Recommendation Report for Planning Permission for Works or Extension to a Dwelling

REF NO: FG/52/22/HH

LOCATION: 6 Beehive Lane
Ferring
BN12 5NL

PROPOSAL: Erection of two storey front extension with front canopy, single storey side and rear extension and extension of loft to habitable use including the installation of 1 x side dormer.

Drawing
Proposed Elevations

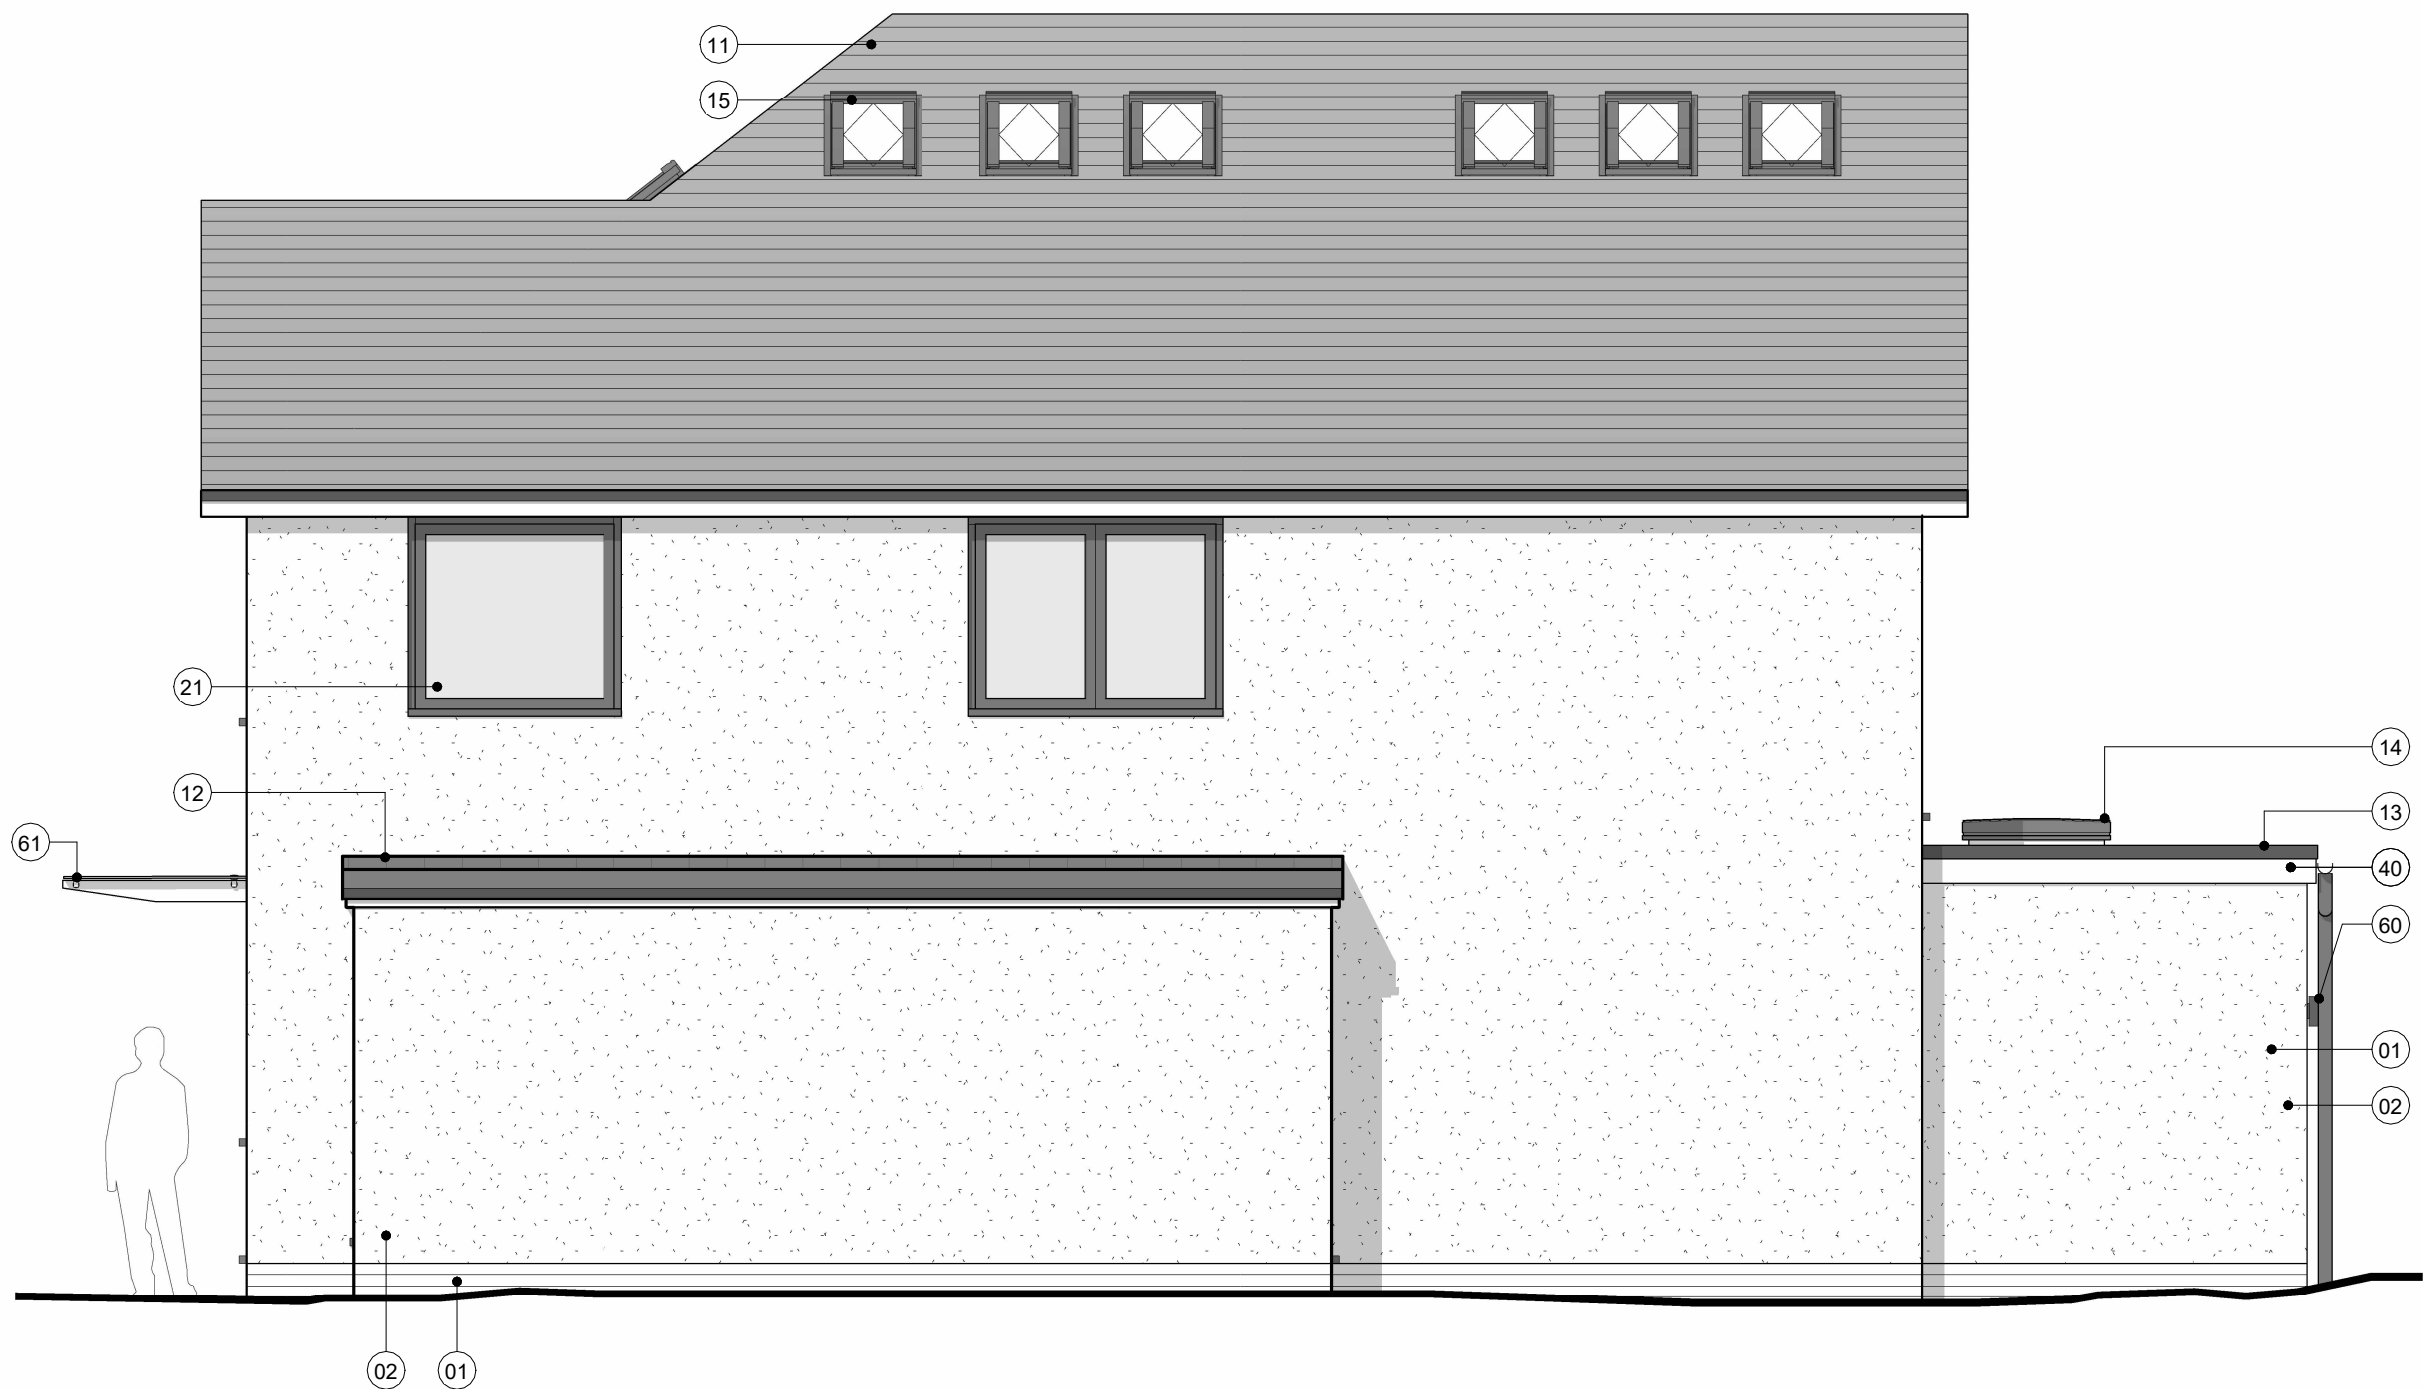
The side extension has a height far lower than the host dwelling and is an extension to an existing side extension, as such it will be a subservient addition to the host dwelling. The proposed box dormer by reason that it has a lower ridge height than that of the host dwelling, its position back from the primary elevation by 3.7m and its retention of the existing eaves line means it will also be subservient to the host dwelling. The two-storey front extension will have the most significant impact on both the street scene and the host dwelling. The design to the frontage will retain key elements of the existing building such as

the bay frontage, eaves line and (although in a different position) a new subservient gable-end protrusion. As such, it will comply with policy in that it will be subservient to the host dwelling. Although new materials are proposed, the new additions are afforded good visual integration by reason that they are consistent and in-keeping with the area which hosts a variety of built materials including weatherboarding.

Comments have been received relating to the box dormer and hip to gable rear extensions being overbearing on the neighbours to the east and south. It is noted that the host dwelling already has rooms within the roof, although only a smaller rear dormer is present. As it currently stands the two-storey property is already significantly larger in height than the bungalow to the east and is incongruent within this grouping of smaller houses. The proposed development will be adjacent to the roof structure of the bungalow and the full effect of the height of the dormer will not be felt by users of the amenity space to the east by reason of this side-to-side relationship. The rear hip to gable extension required to facilitate the dormer will be contained within the confines of the existing buildings footprint so will not overbear neighbouring properties. In terms of overshadowing the increase in ridge will have some effects of overshadowing but this will be predominantly to the roof of No 8 (east) in the late afternoon and to the side elevation/roof of 4A (west) in the morning, given most of the structure is already existing this will already occur to some extent. Although there will be an impact from overbearing and overshadowing, it will not cause significant harm.

Comments have also been received regarding concerns for privacy through overlooking. No new views which are not already achievable will be created from any of the proposed fenestration located on the northern or western elevations. The roof lights to the western elevation appear to be above 1.7m from finished floor level, other windows face the public realm. The windows to the east are described within plans as obscure glazed, all other windows above ground floor levels are as existing. The glazed gable to the southern elevation has a direct back-to-back relationship with No 4 Chalet Close. The glazing at first floor level to the southern elevation will be lessening and will therefore improve the situation however, new glazing will be introduced at second floor level. This glazing replaces a much smaller rear gable which is set back by over 1.5m from the rear line of the elevation, by moving the glazing forward the 1.5m only 19m is retained between the two facing elevations, without control this would provide an unacceptable form of development. This window along with the other side windows/veluxes mentioned above will be conditioned to be non-opening and obscure glazed, to protect the privacy of all surrounding neighbours.

- Location and Block Plans 1002
 - Proposed Plans 2002 02
 - Proposed Elevations 2003 02
Reason: For the avoidance of doubt and in the interests of amenity and the environment in accordance with policy D DM1 of the Arun Local Plan.
- 3 The second floor rooflights/windows hereby approved to the western, eastern and southern elevations shall be non-opening and fully obscured windows below 1.7m from finished floor

level prior to the first use of the rooms. The windows shall be retained as obscure glazed/non-openable in perpetuity.

The first floor window to the western elevation serving Bedroom 2 shall be a non-opening and fully obscured window below 1.7m from finished floor level prior to the first use of the rooms. The window shall be retained as obscure glazed/non-openable in perpetuity.
